November 20, 2009

RE: **355 Warren Avenue (Tow Lot)**
Minor Site Plan (maximum of 70 vehicles to be stored)
Application ID # 2007-0138

TO: Jean Fraser
FROM: Dan Goyette, PE
DATE: November 13, 2008
RE: 355 Warren Avenue

Boundary Name and Location  
**BOUNDARY SURVEY/EXISTING CONDITIONS**  
 355 WARREN AVENUE, PORTLAND, MAINE

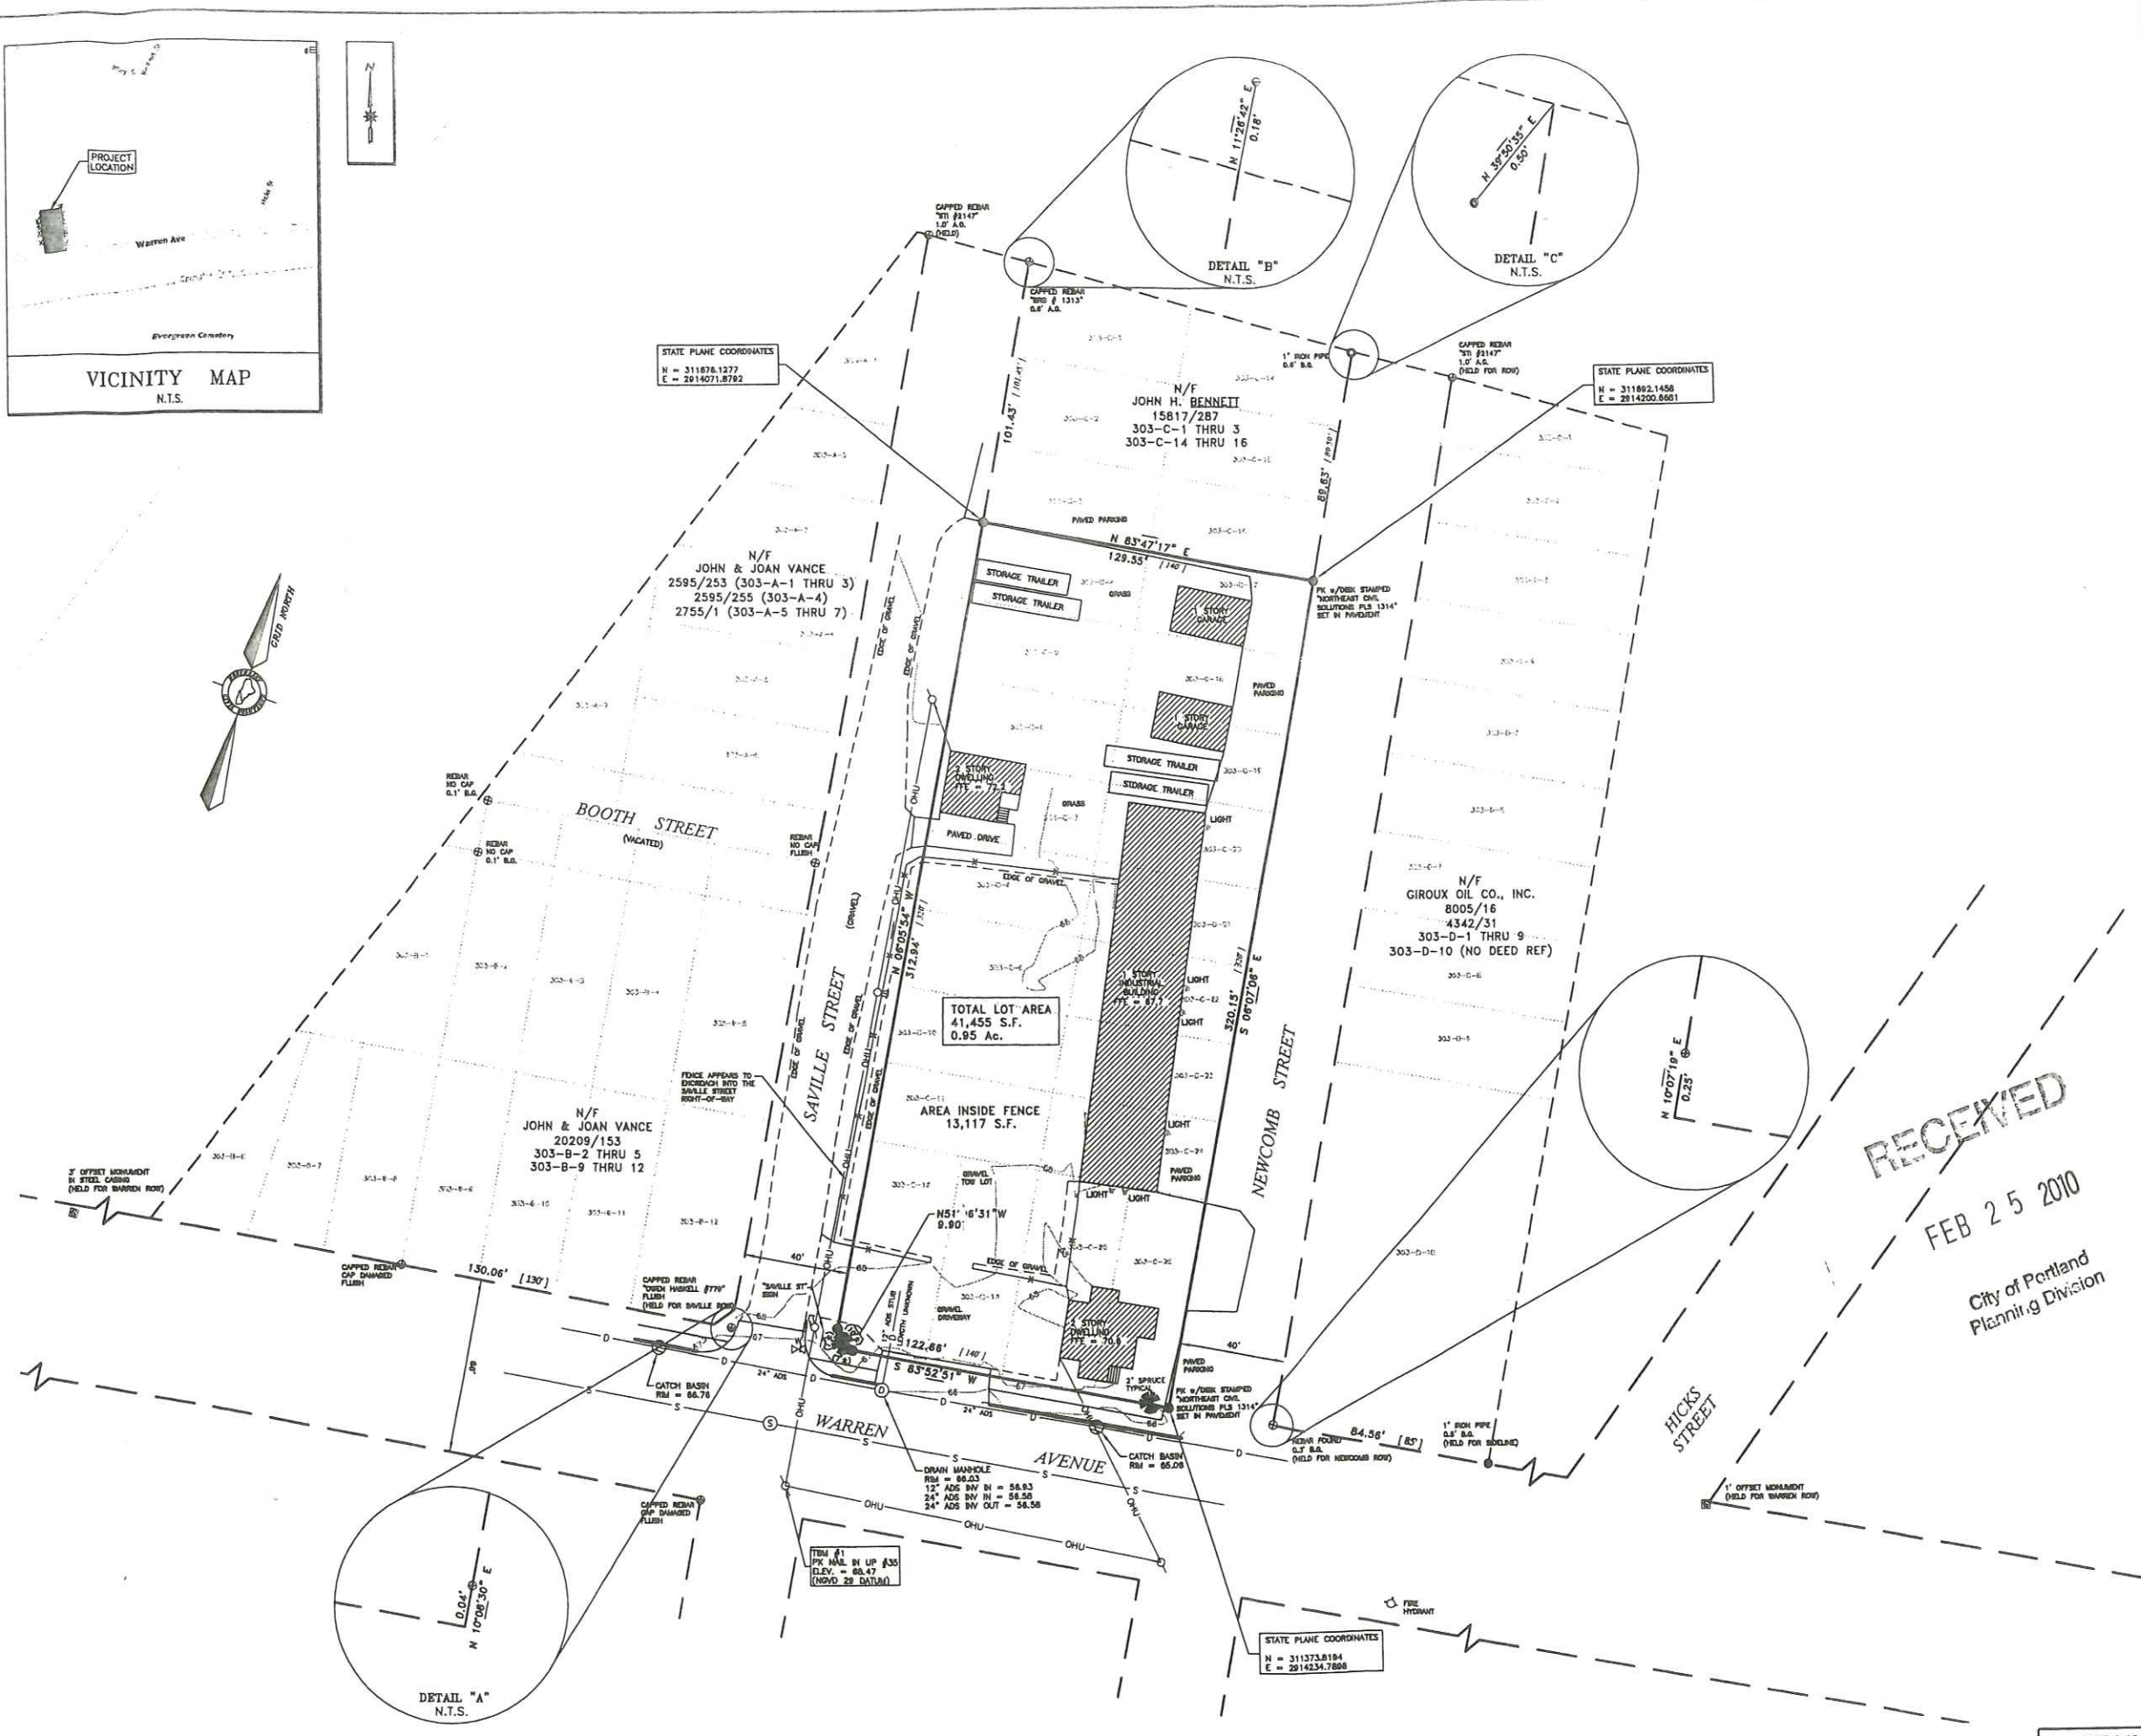
1. As confirmed in previous letters and at the 9/29/2008 meeting with Mr Jaegerman, a complete, up-to date and stamped standard boundary survey. Please note that given

the passage of time and the intervening site alterations (e.g. demolition and other work to 353 (aka 345) Warren Ave within the site, documented in Attachment 2, and the MDOT improvements in the ROW) an updated survey (i.e. as of November, 2009) is now required. The survey must specifically address the comments in the 11/13/2008 Memo from Woodard & Curran (Attachment 1) and clarify the current ownership of the lot to the rear of the tow lot (303-C-1-3 and 303-C-14-16) as our records indicate that this may be owned by another party.

- The applicant should confirm that the survey for the project coincides with approved City standards. The applicant states that this requirement has been waived but we are not aware of any such agreement. If there is not an agreement, the survey needs to be tied to the vertical datum of NGVD 1929. Also, the project needs to be tied to the Maine State Plane Coordinate System (2-zone projection), West Zone using the NAD 1983 (HARN) Datum and the U.S. Survey Foot as the unit of measure. This should be indicated on the survey.
- Erosion Control Measures have not provided.
- The manhole detail shows only RCP while the plans show ADS N12 pipe. ADS N12 pipe is not allowed within the City Right-of-Way.

**SITE PLAN**

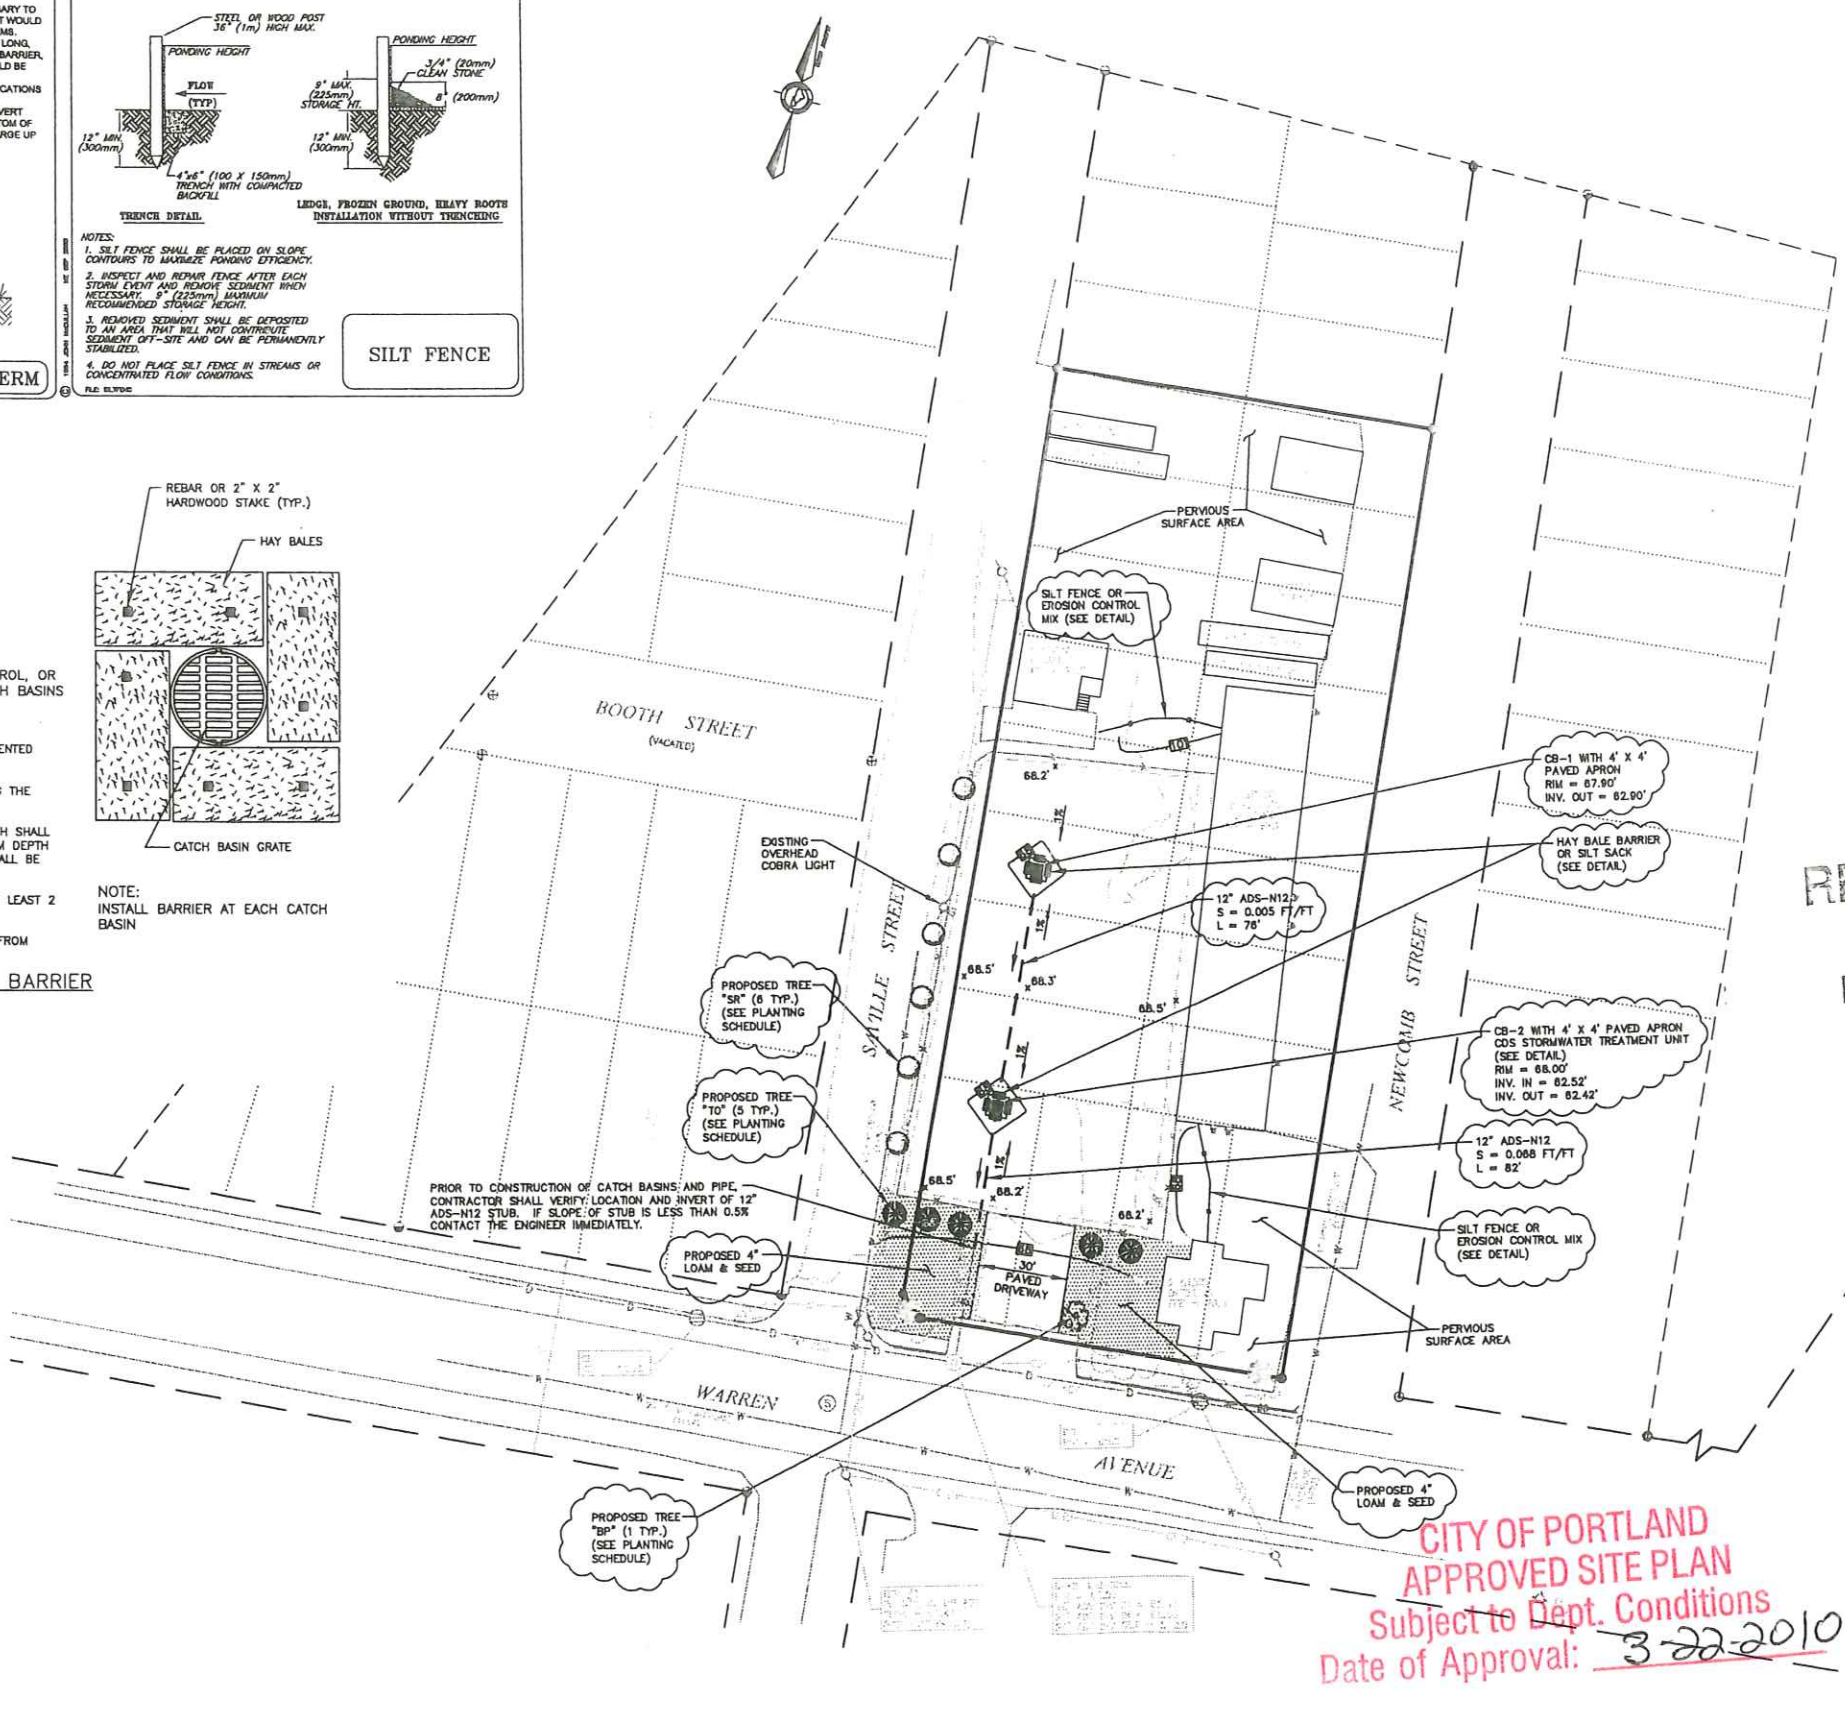
2. The site plan needs to be revised to address the detailed engineering review comments regarding erosion control and pipe details (Attachment 1).
3. The site plan needs to specify the size and type of planting. Jeff Tarling, City Arborist would be willing to advise on this (he can be contacted on 874 8462 or JST@portlandmaine.gov).
4. The site plan needs to be revised to be consistent with the updated boundary survey and include the recent alterations to the fencing, 353 Warren Avenue, and the ROW (the latter should be as in the letter to MDOT of 11/03/2008 in Attachment 2).
